Our Ref: AL/26/08/

7th April 2008

Outline application for new dwelling alongside 10 Lidsey Road with all matters reserved
 10 Lidsey Road Woodgate Aldingbourne

Proposed Site Plan

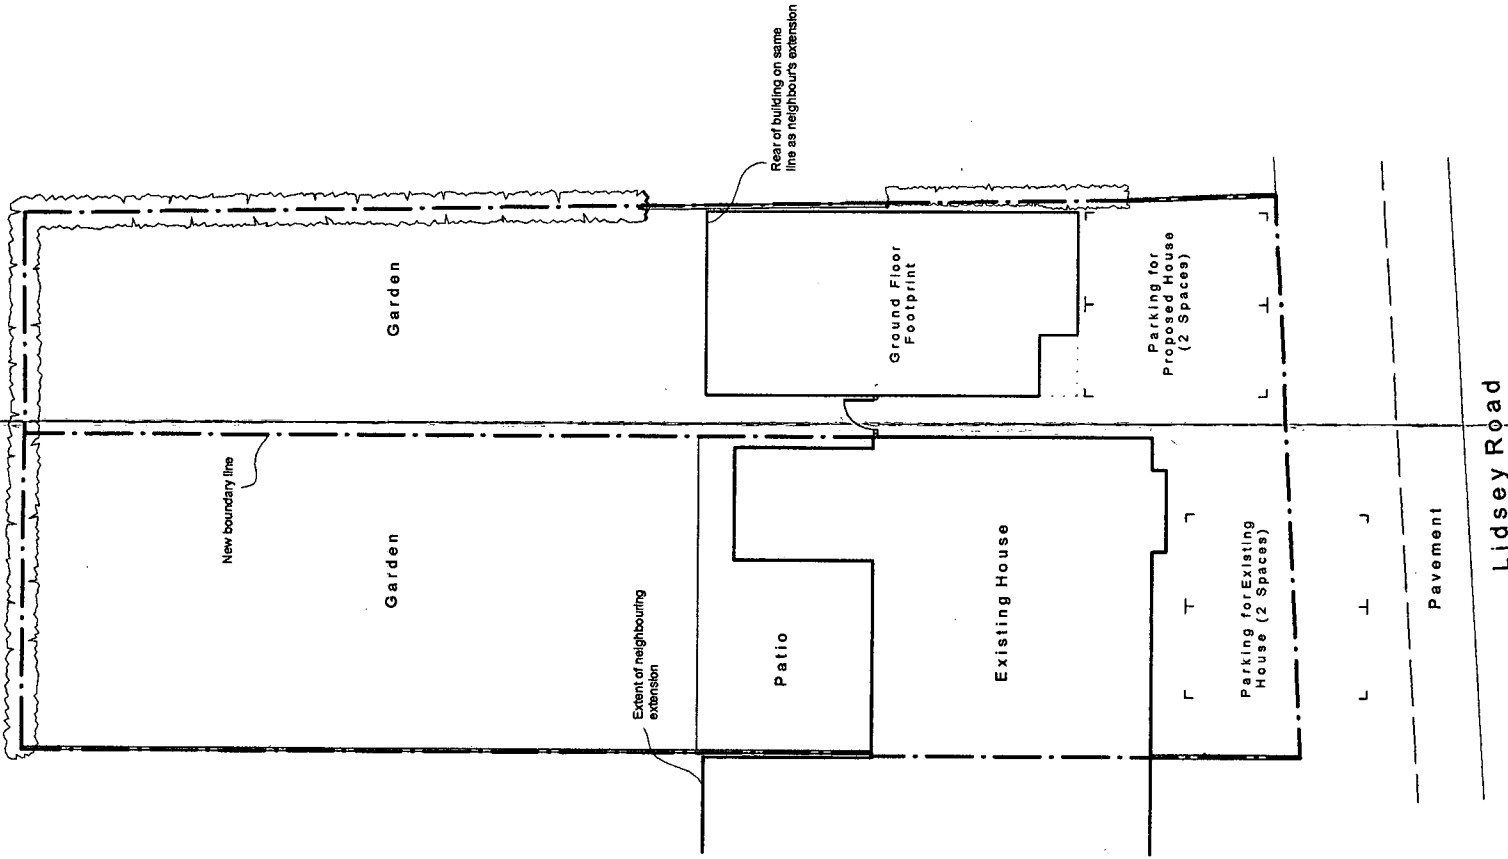
The plot is considered too narrow for another dwelling.□

Limited parking space would result in vehicles reversing onto the A29 to the detriment of highway safety.□
